Re : proposed development at 70a Tarrant St. Arundel BN18 9DN .

Ref : AB/118/20/PL

Date : 9 December 2020

Drawing Name
Plans - proposed

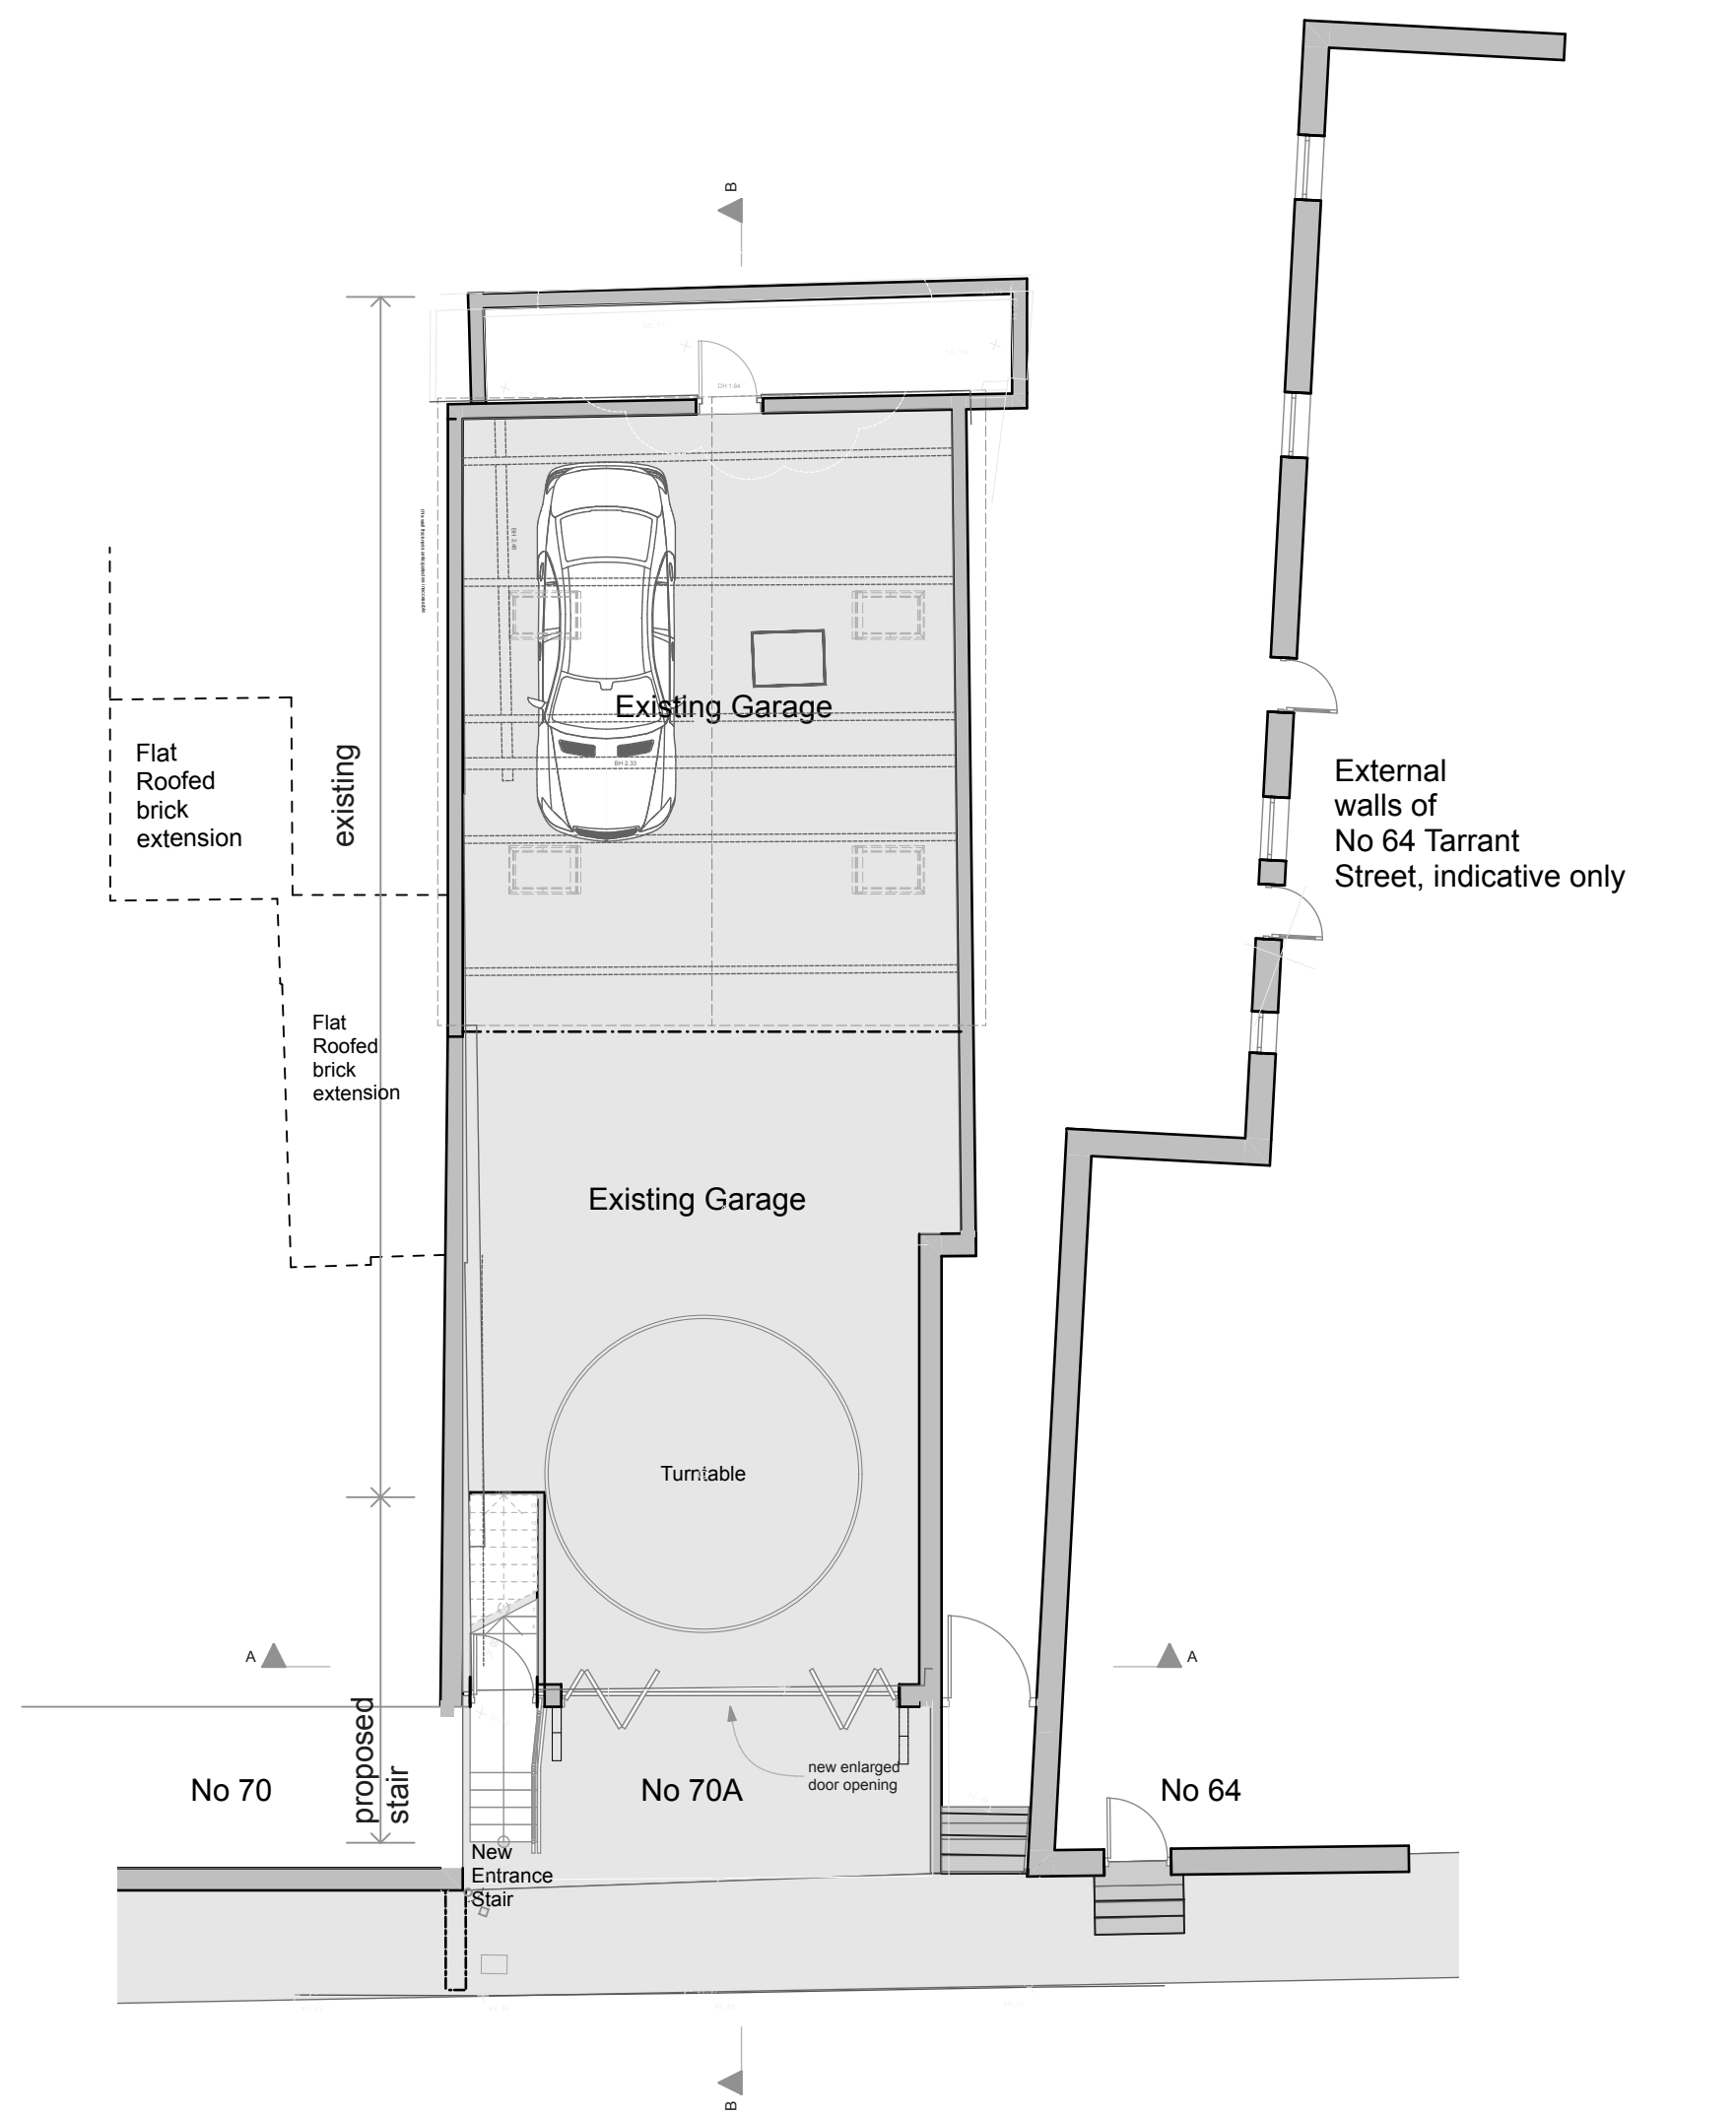
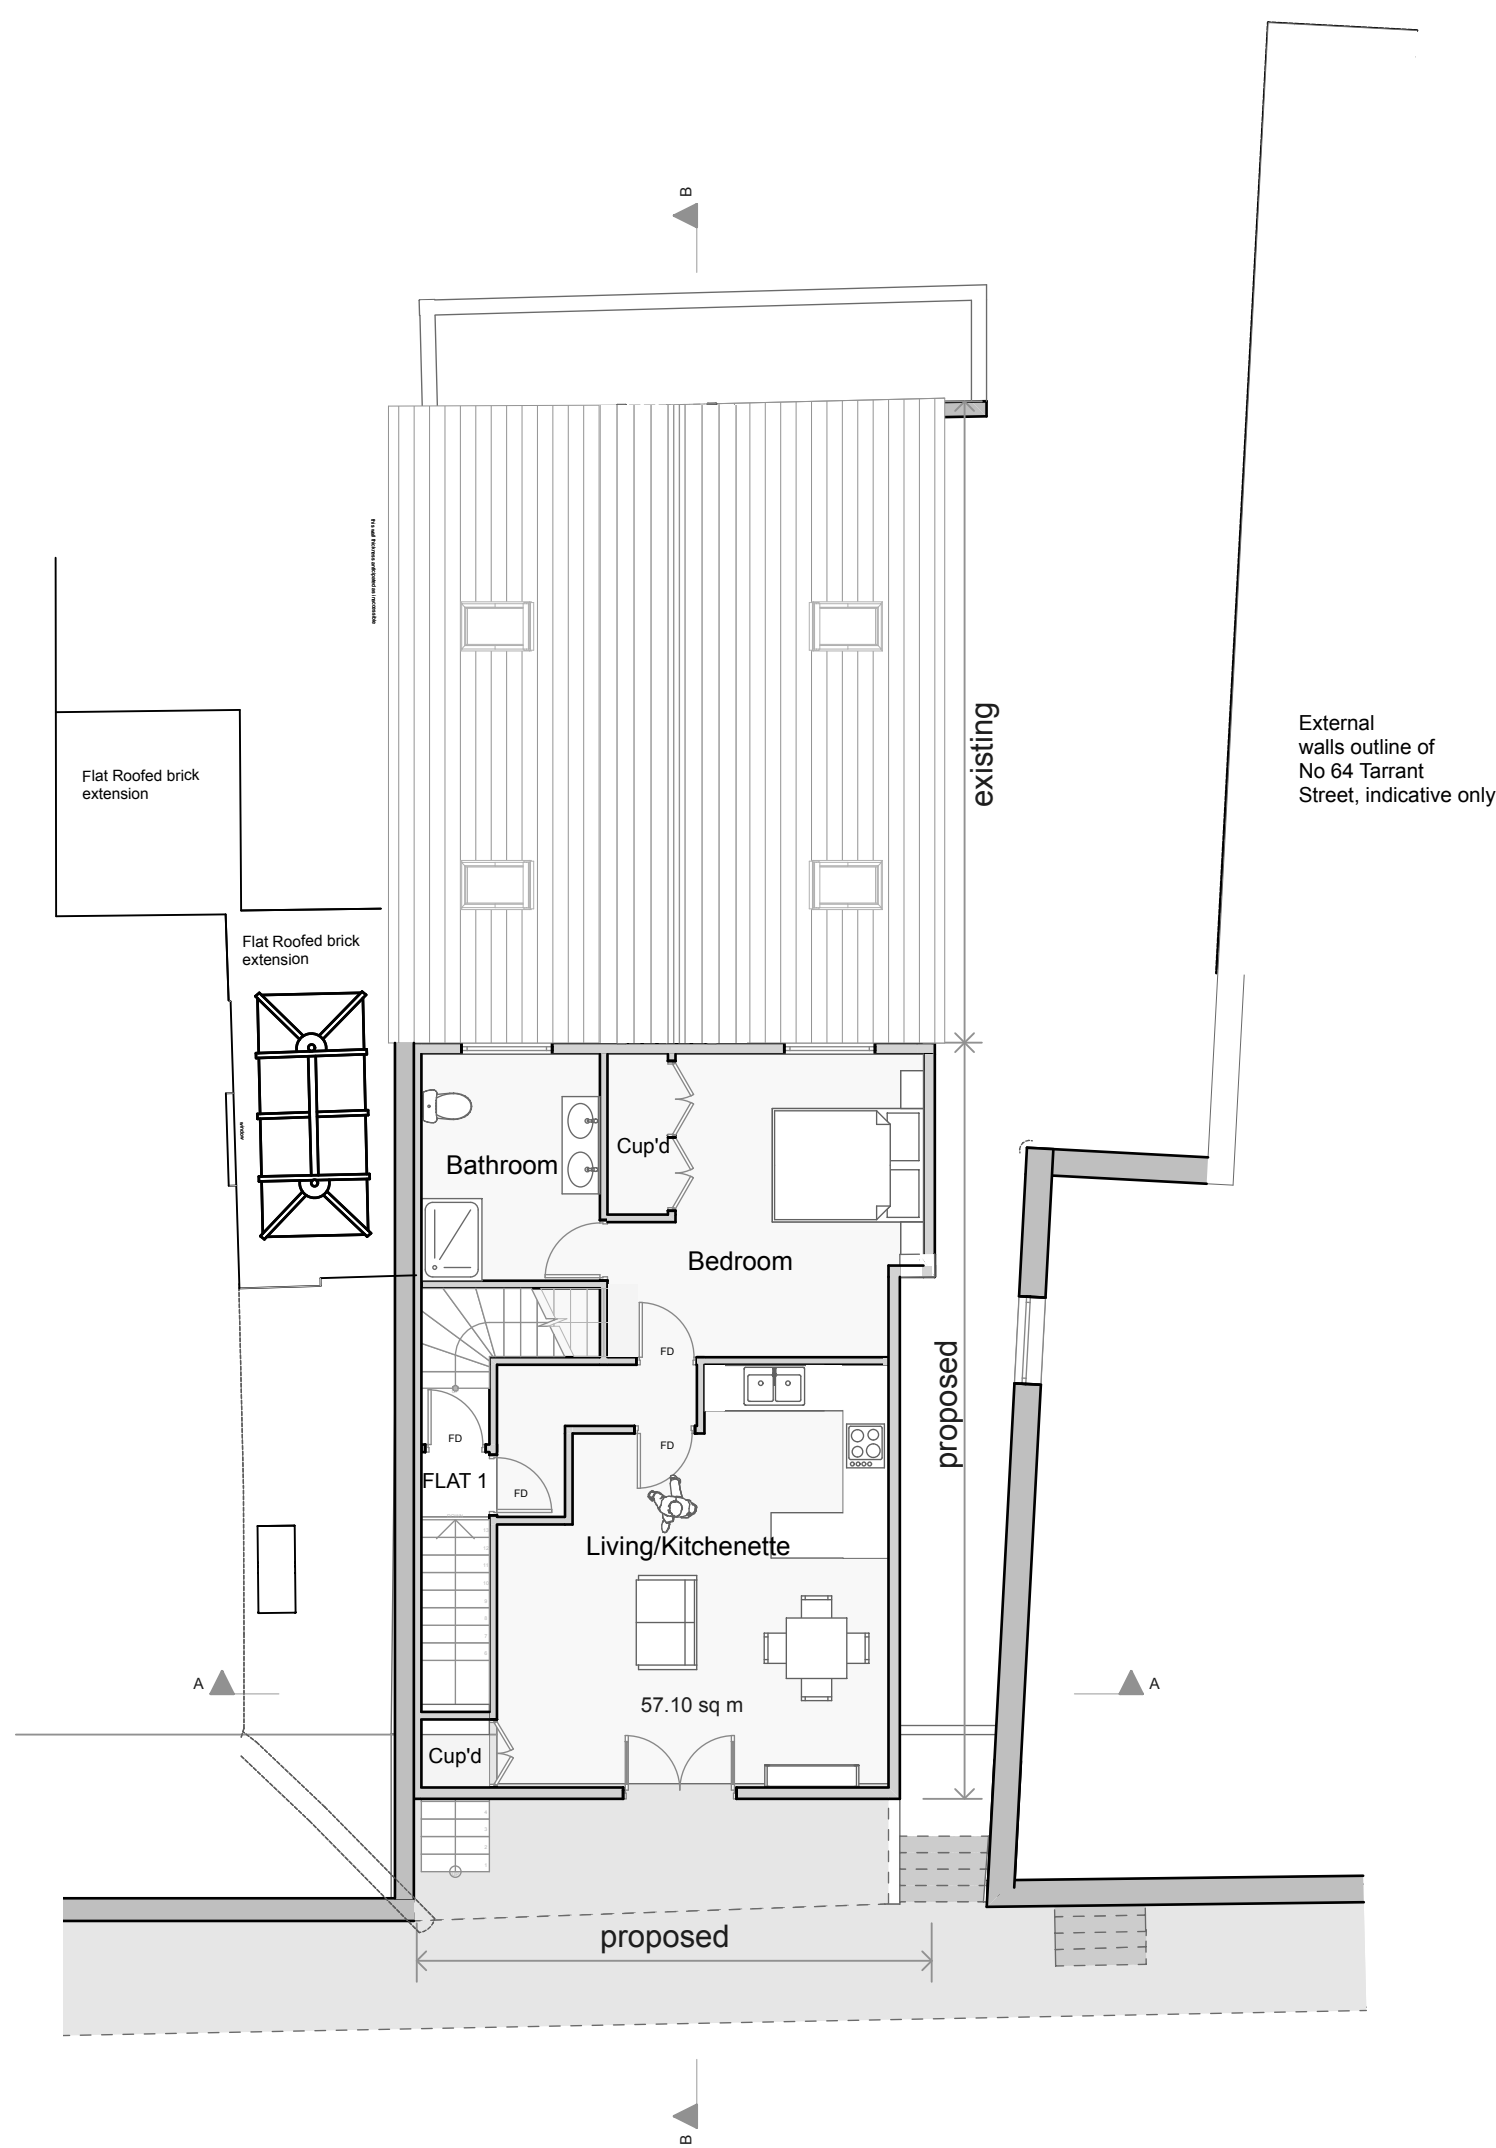
I note that the 1/100 plans are without any dimensions or datum levels with a bench mark, needed to accurately confirm the sensitive physical bulk and height and position of overlooking windows into 64 Tarrant st, of the proposed development which will cause serious loss of light to the flank wall windows being the two at first floor level and an even greater loss of the already shrouded light to the more sensitive ground floor window which gives light to the sitting room.
